Application No: Y/32/25/PL

Site Address: Land West of Bilsham Road Yapton BN18 0LA

Description of works: Erection of 170 No. residential dwellings (30% affordable), parking spaces, internal site roads, public open space, children's play space, pumping station, surface water drainage features, landscaping and associated works. This application is a Departure from the Development Plan and is in CIL Zone 3 and is CIL Liable as new dwellings.

Thank you for your internet representation made on 9th June 2025 which has been recorded as an objection with the comments as follows:

Figure 3.1: UK Habitat Plan – post development

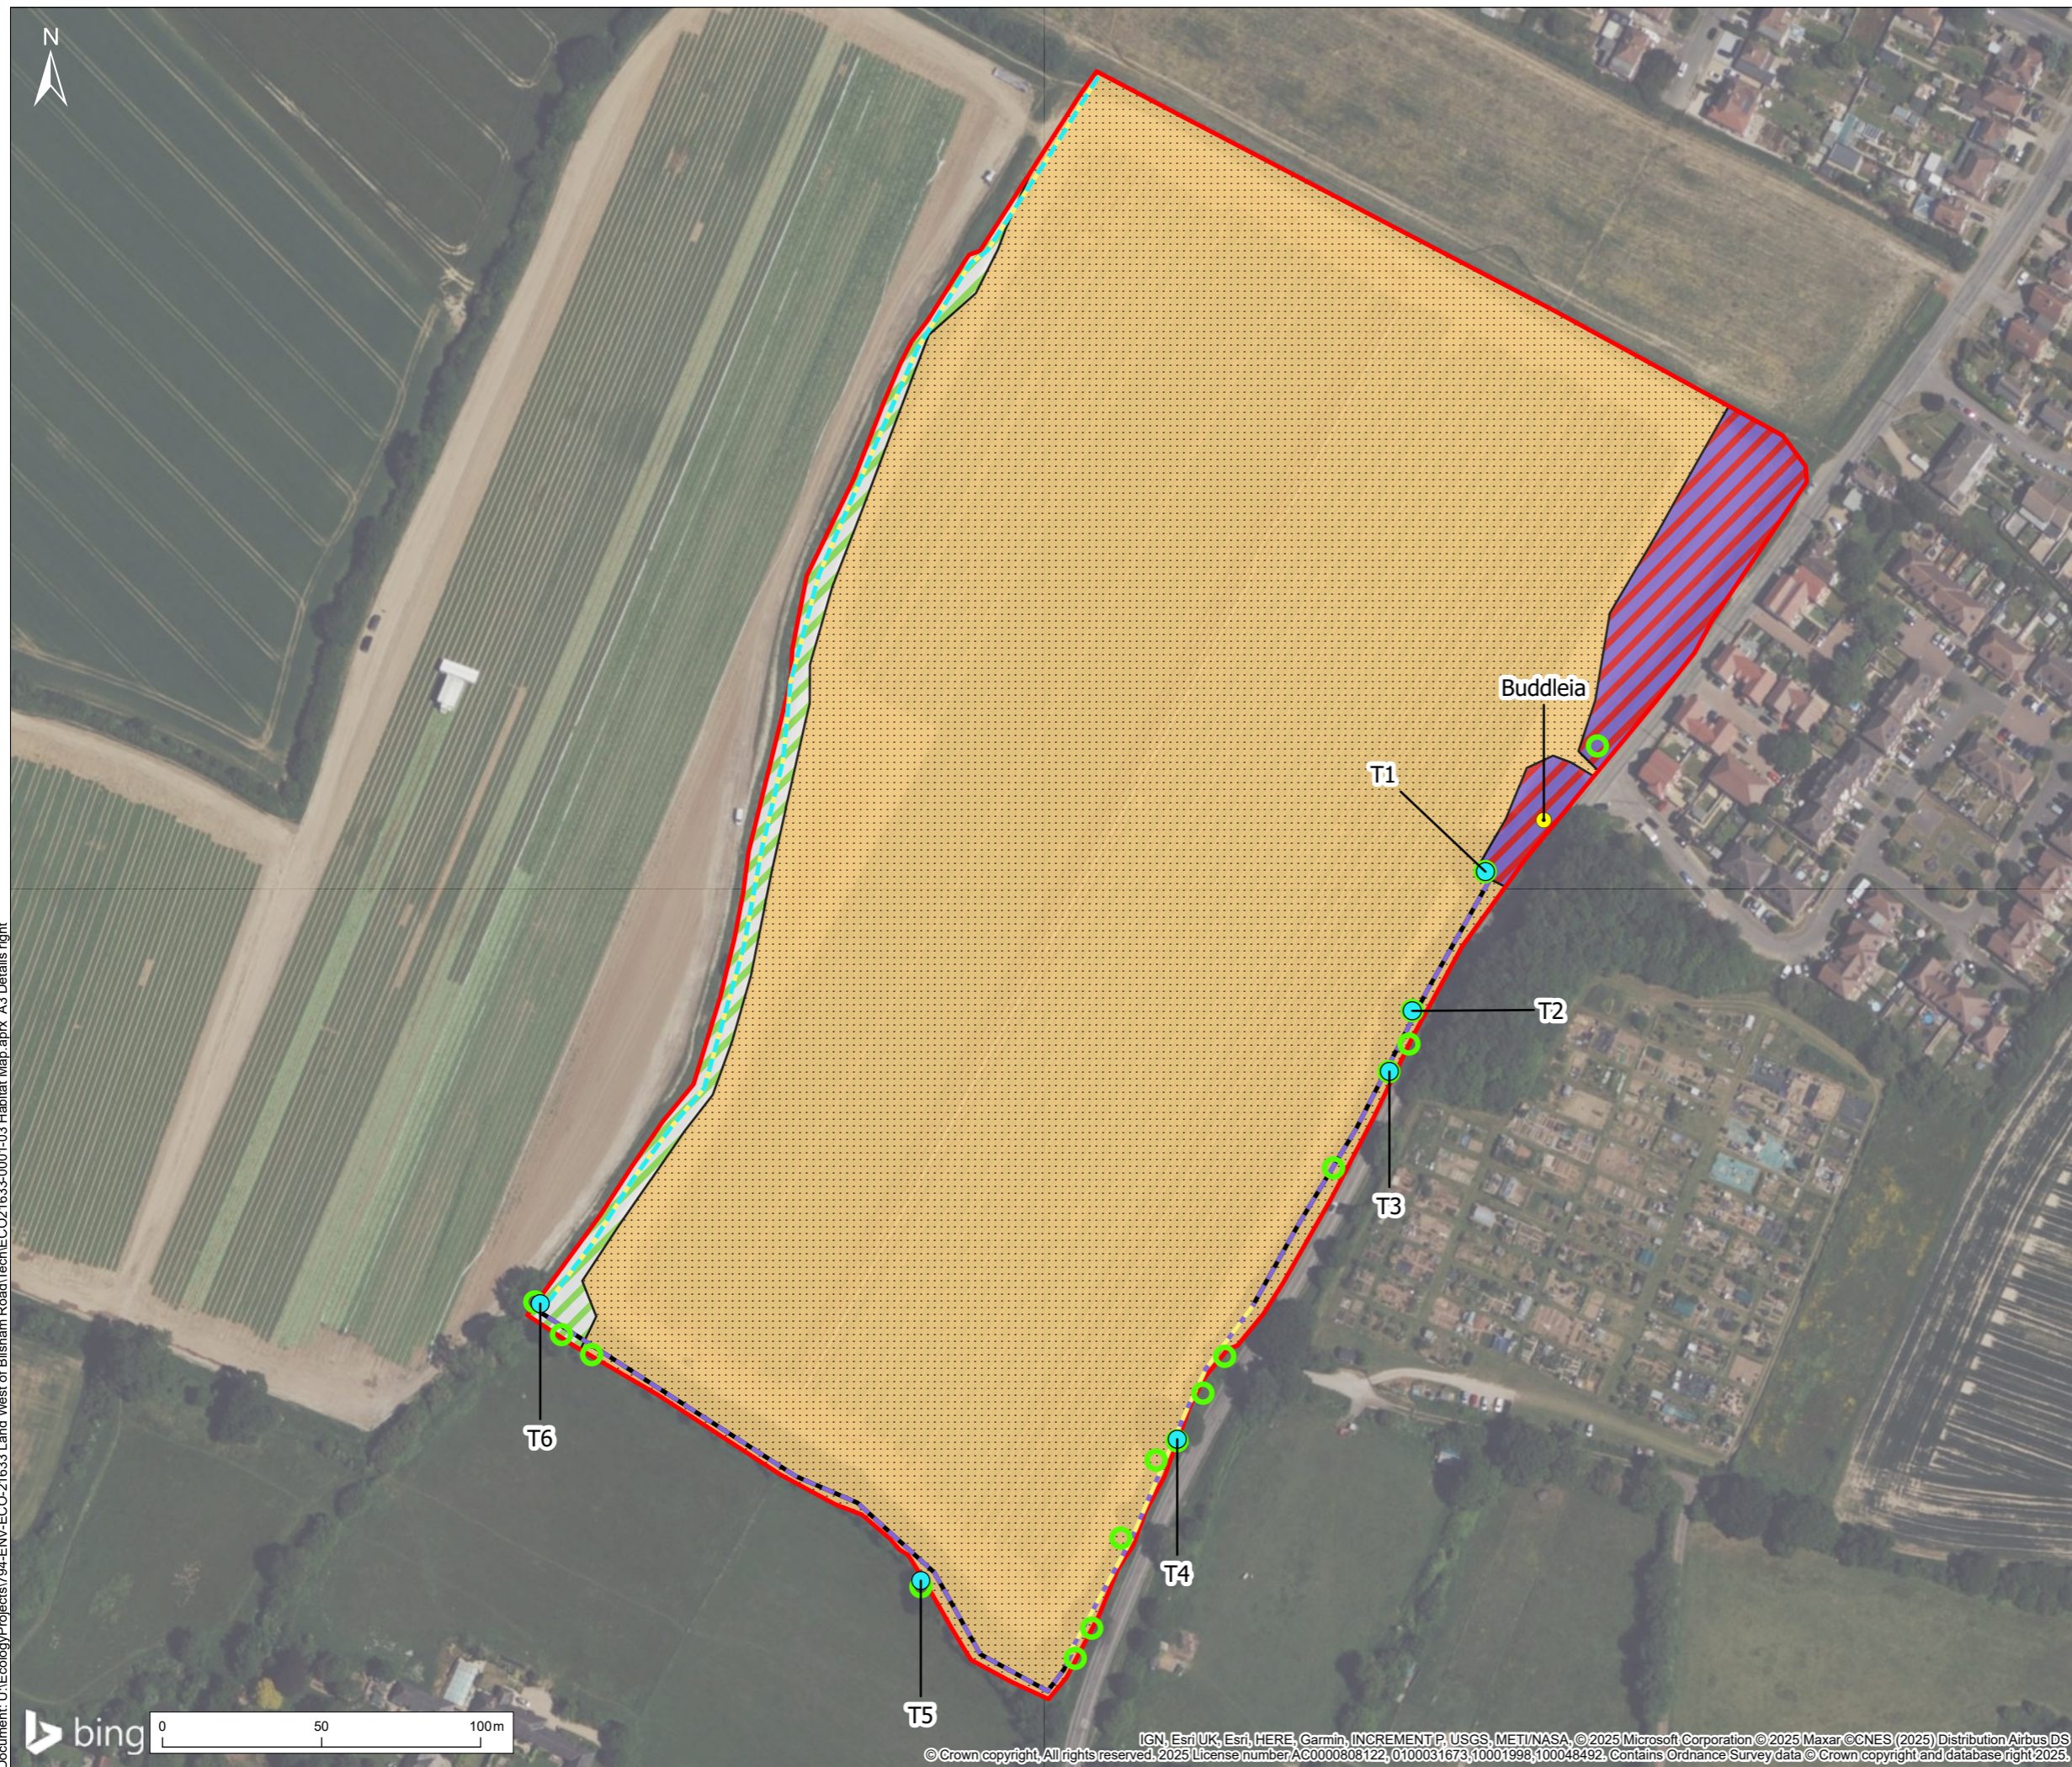
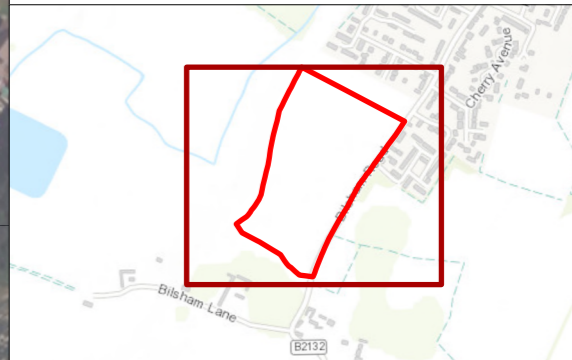
YPC note that almost 50% of the southern area of open space is occupied by a single SUD/drainage basin. YPC cannot accept this unless it is landscaped in such a manner to reflect a natural reed bed or equivalent. The applicant has a similar feature within its development South of Ford Lane (Meadow Gardens) which is an eyesore and provides little added environmental gain to the overall open green space. YPC fails to understand how this current proposed feature positively contributes to any biodiversity net gain.
